Arun District Council
Arun Civic Centre
Maltravers Road
Littlehampton
West Sussex
BN17 5LF

Our Ref: SDNP/20/03333/ADJAUP
Contact Officer: Vicki Colwell
Tel. No.: [REDACTED]

Neighbouring Authority Consultation

Proposal: Adjacent Authority Consultation - A/110/20/RES - Approval of reserved matters following A/99/17/OUT for the Bridge over the Black Ditch providing access to the approved development. This application may affect the setting of listed buildings, may affect the character & appearance of the Angmering Conservation Area & falls within Strategic Site SD9, CIL Zone 1 (Zero Rated).

Sussex View

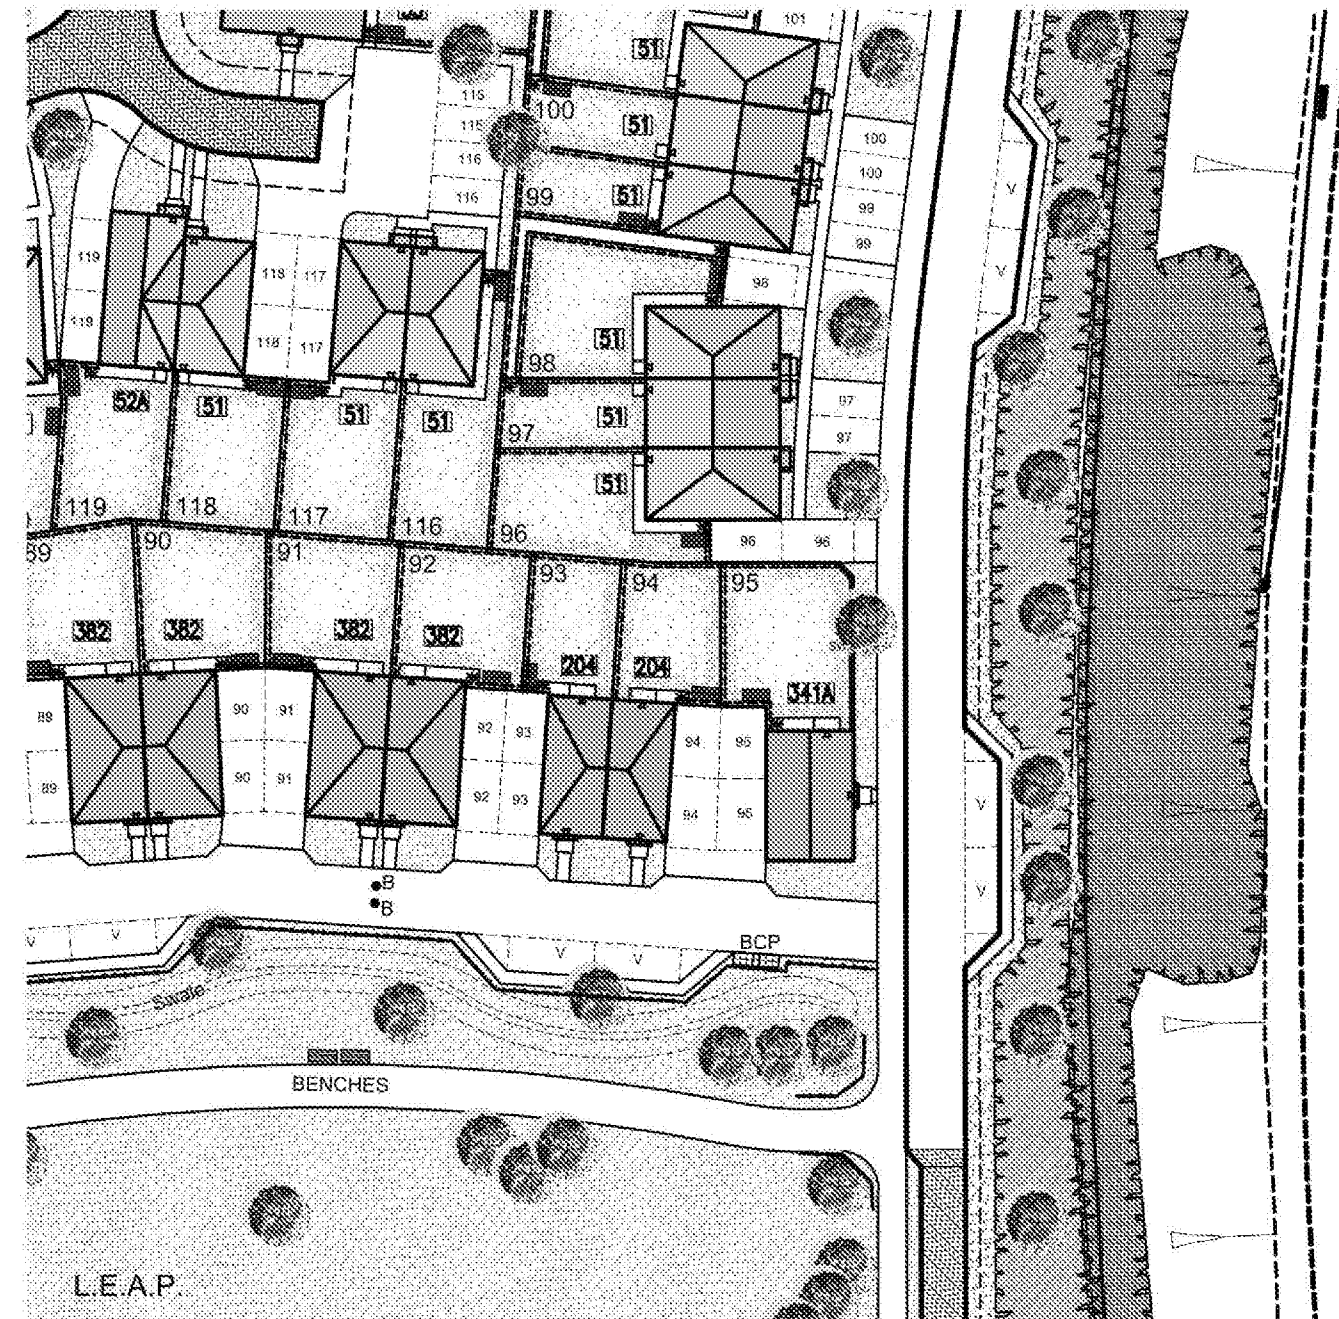
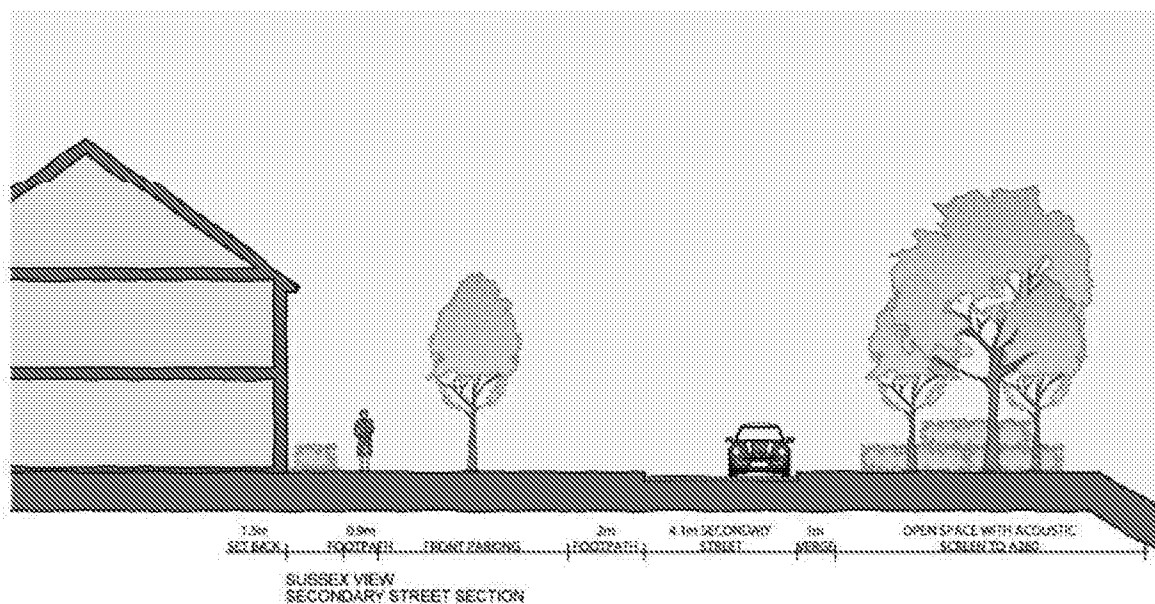
The planting scheme indicates that a single line of regularly repeated tree species would be provided, several of which are proposed to be non-native ornamental or evergreen varieties. The submitted DAS also refers to the "Sussex View" character area which offers an "aspect over the National Park" with "dwellings benefiting from scenic views of the National Park," indicating that the buffer would be sufficiently sparse and/or broken up to allow clear views out of the site. The submitted Street Scenes plan 1-1150 indicates that the "Sussex View" dwellings which face outwards along the eastern edge of the development, appear to be of a uniform 2-storey ridge height, aside from the large apartment block in the north eastern corner.

It is the view of the Authority that the design of development generally should be of a high standard so as not to require screening; however, in this case it is accepted that a woodland buffer is necessary to mitigate the impacts of development on the National Park setting. However, the buffer as proposed is insufficient to provide adequate screening the development, let alone support multifunctional recreational or wildlife corridor benefits. To achieve the level of screening necessary, and given the scale and height of the new dwellings (in particular the large apartment block comprising units 159-167) the buffer should provide a wooded belt of a sufficient width/depth of local native tree and scrub species to ensure minimum/glimpsed views of the development, and to assist the scheme in achieving biodiversity net gain.
